Please accept the objection below to Planning Application No. 2025/62/92181/E

We regard the revised planning application at 382 Huddersfield Road, Mirfield as essentially no different from the previous one. We therefore make the same objections as before, which I set out below for your convenient reference.

Drawing Title:
Location & Proposed Site Plan

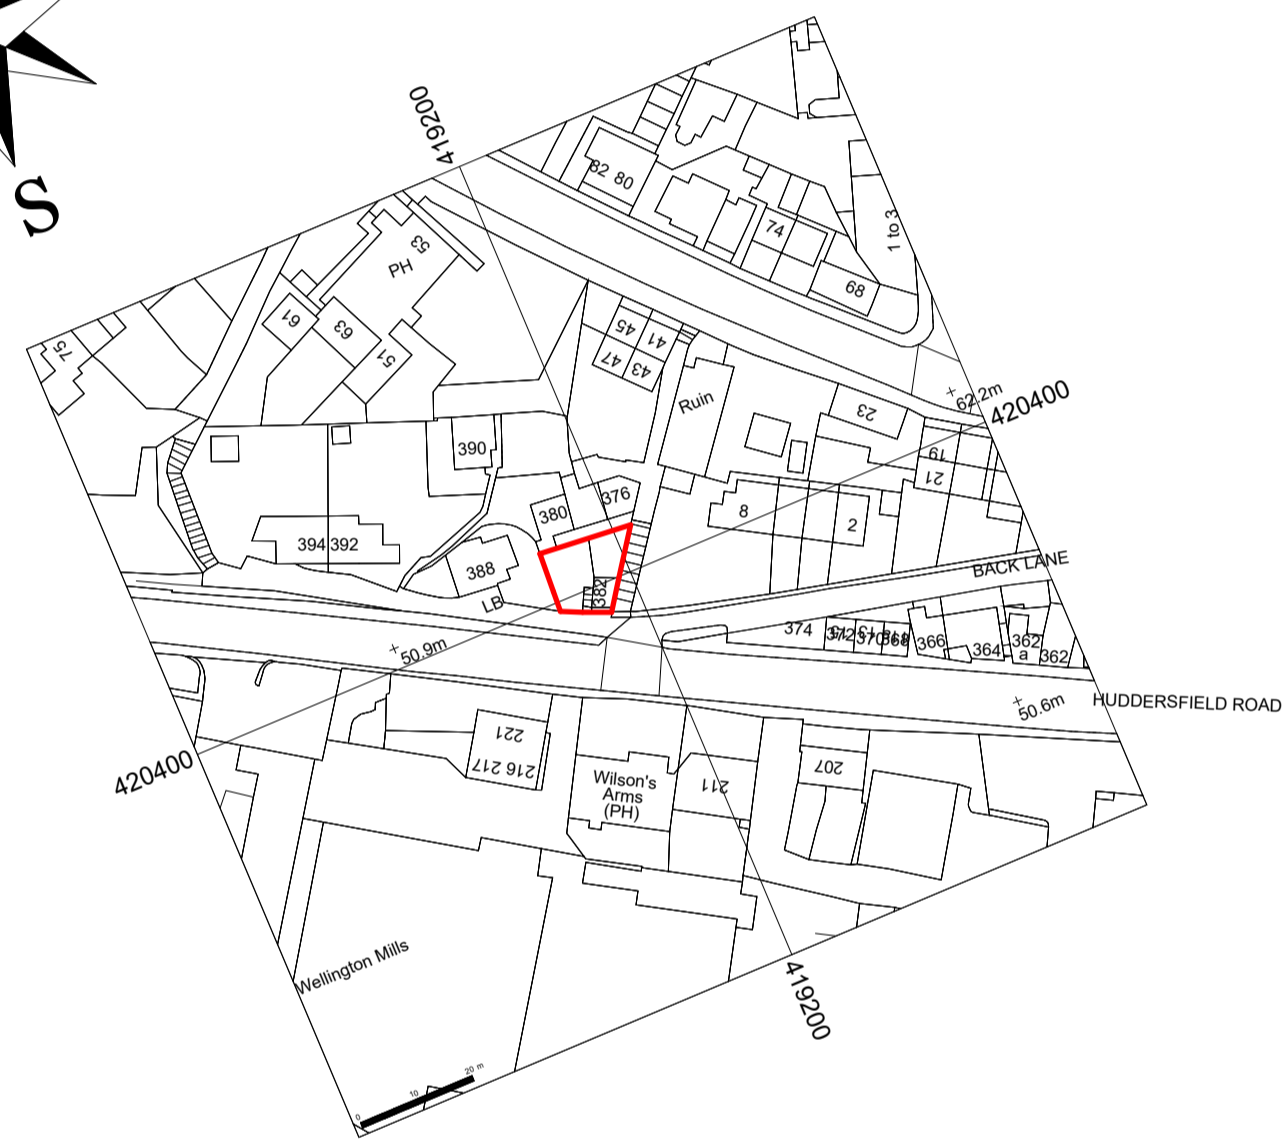
Inadequate and unsuitable bin storage would further detract from the appearance and proposed operation of the premises.

The stipulated access on the plan does not include access at the rear of the property where a wall/fence has already been constructed, a gap has been left in the wall/fence to which I object for use as access as this is not covered by the planning application.

Drawing Title:
Proposed Grouped Plans

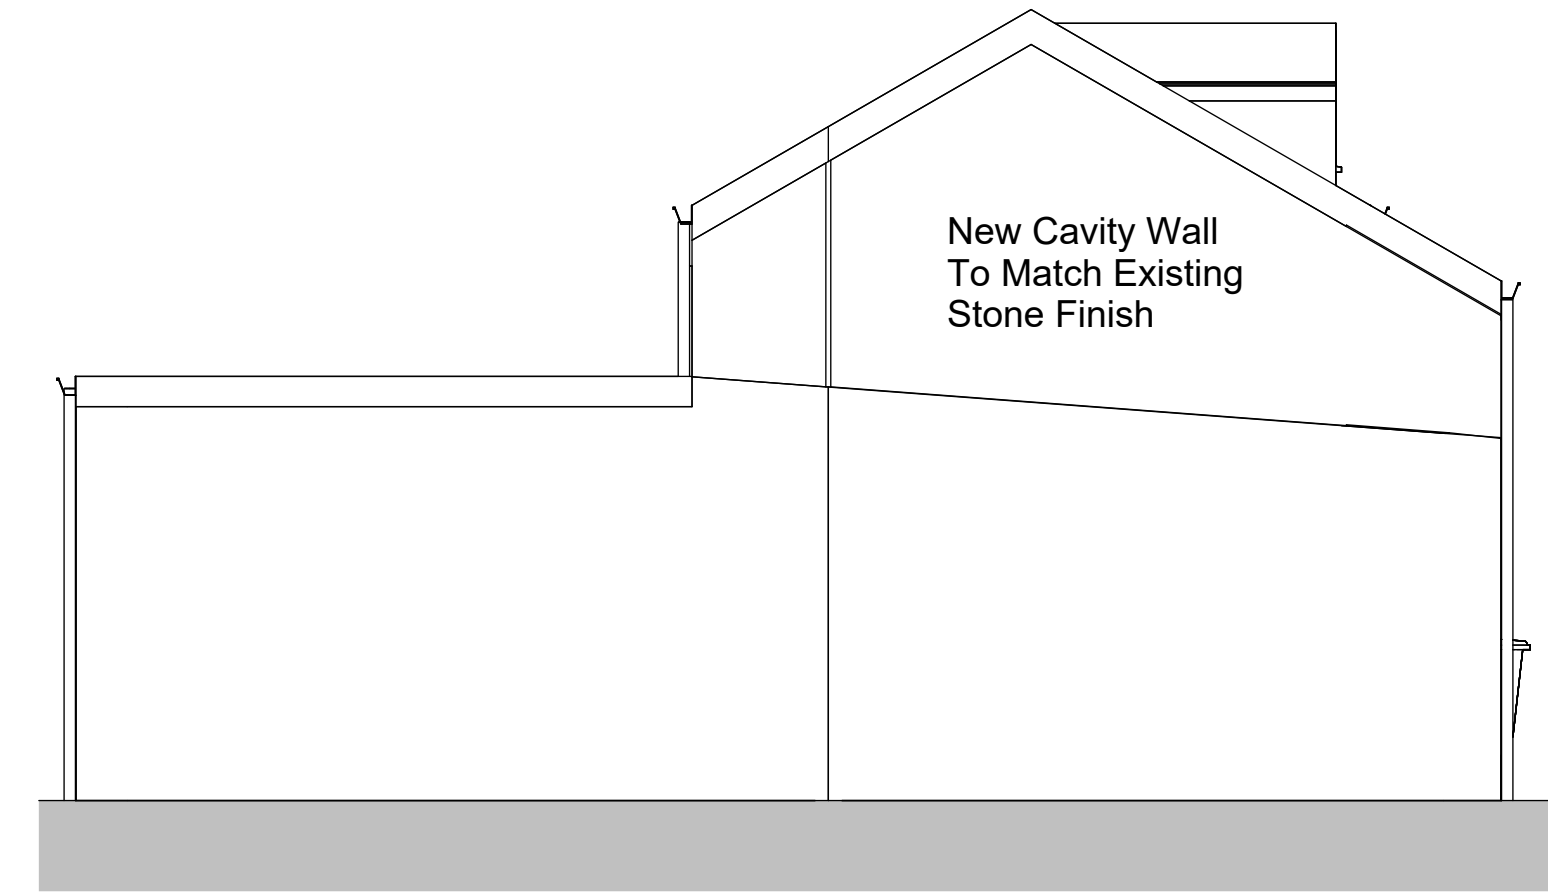
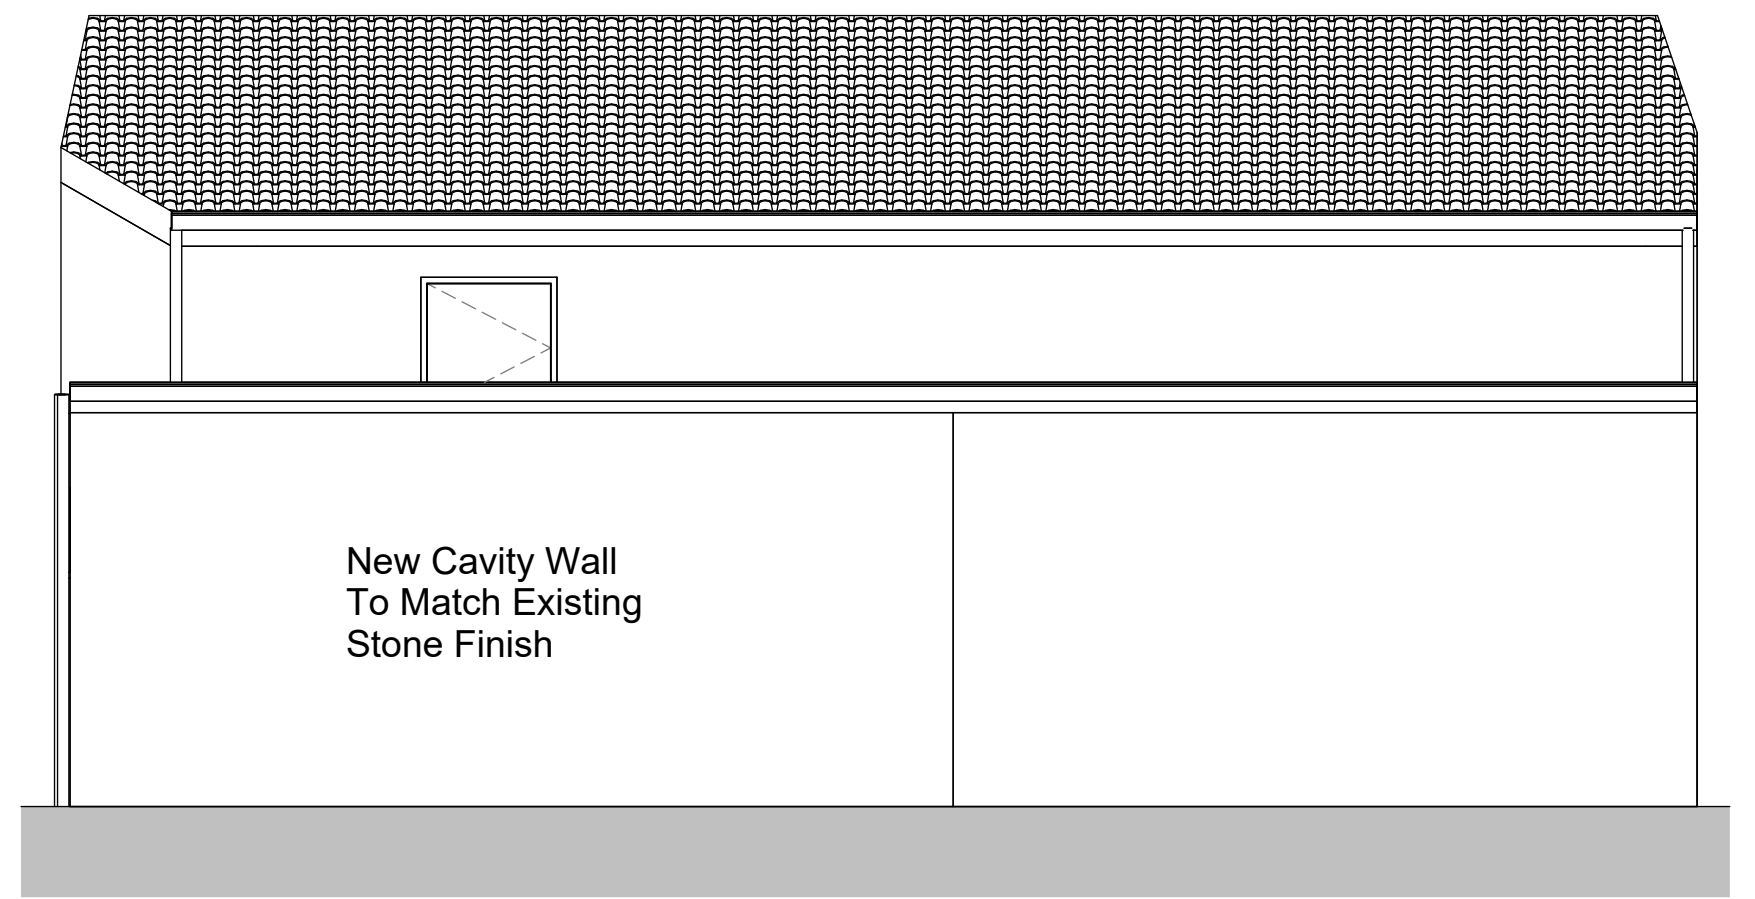
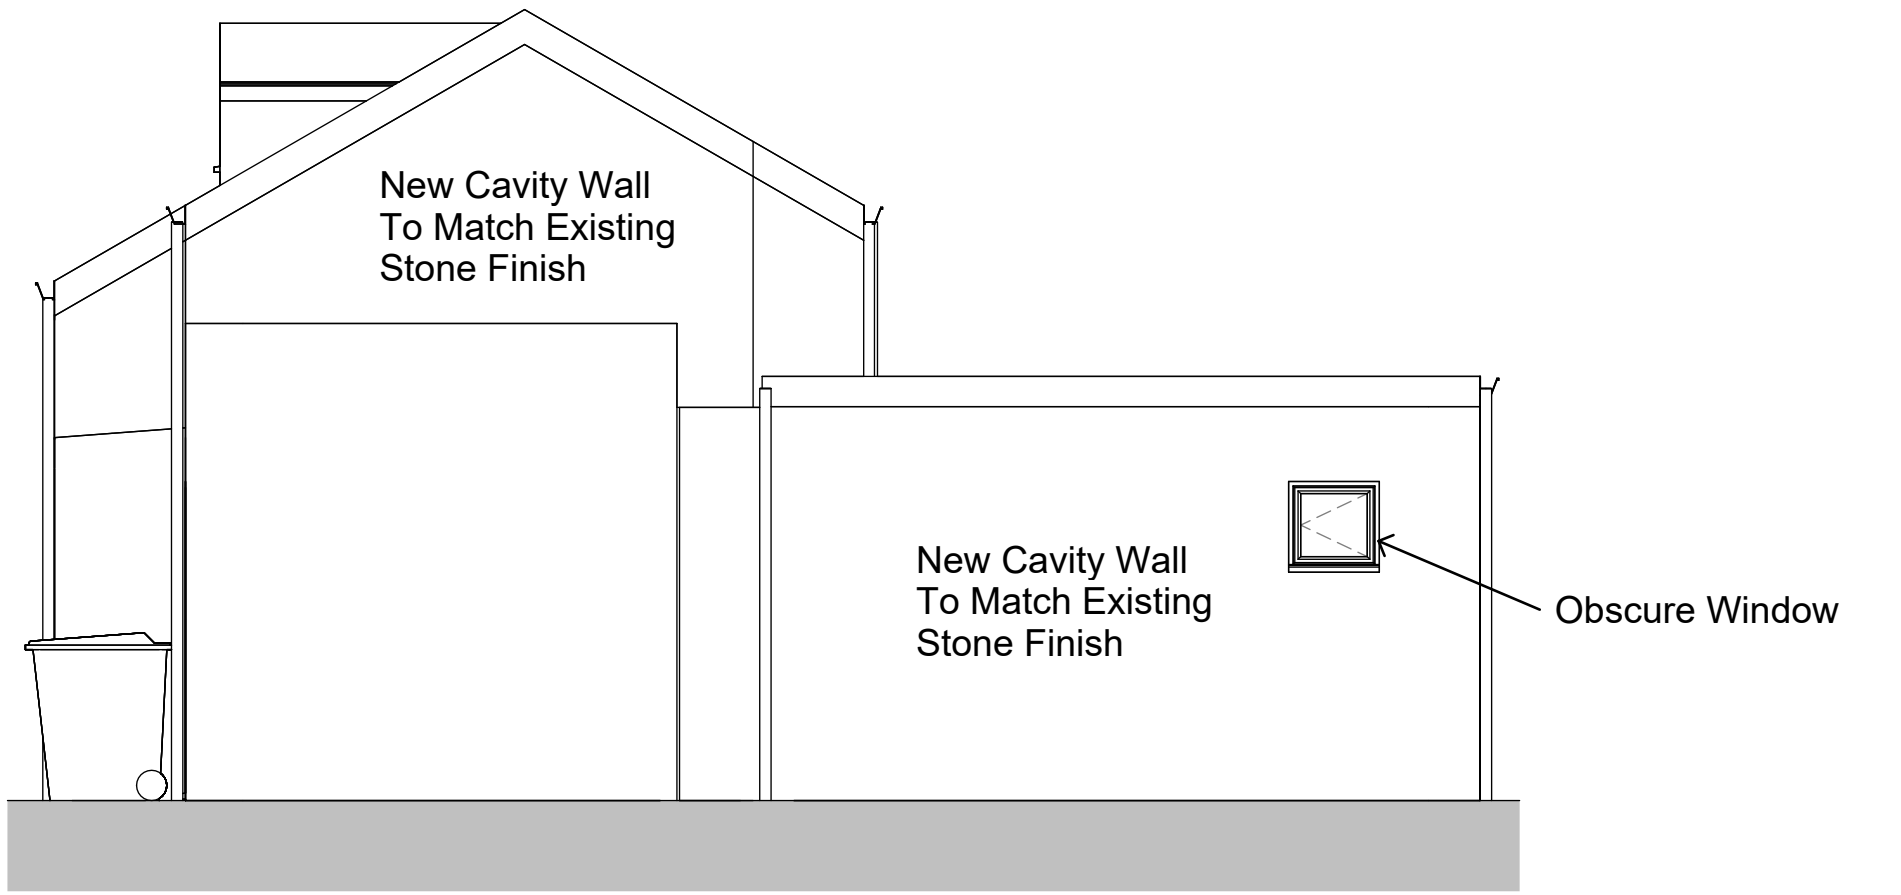
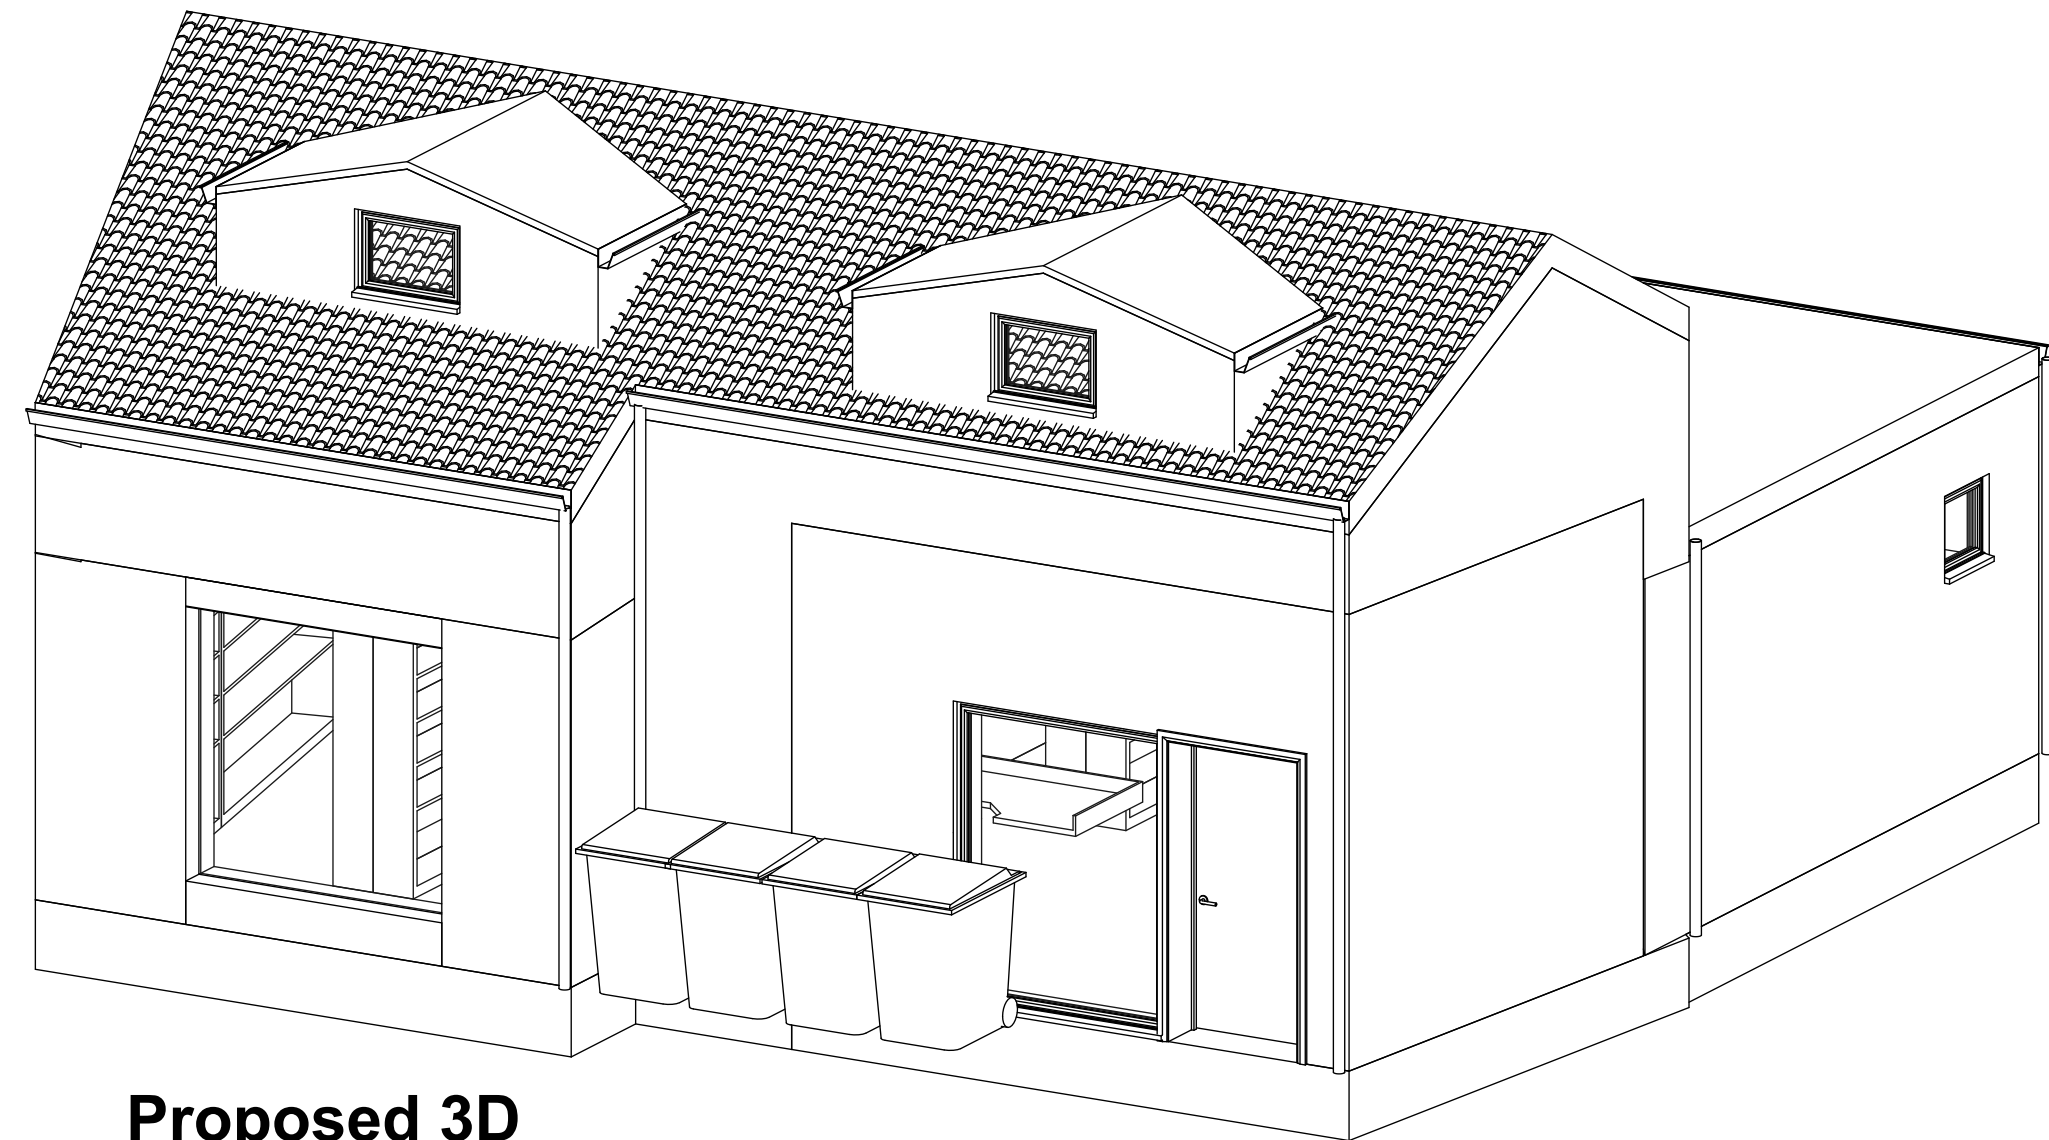
In addition, since the title of the planning application and the accompanying plans emphasize the proposed vertical extension, We object to any increase in height. This would make the new structure overbearing and it would make the adjoining public right of way from Huddersfield Road/Back Lane to Stocksbank Road oppressive. It would also interfere with light for Nos. 376, 378 and 380, Huddersfield Road.
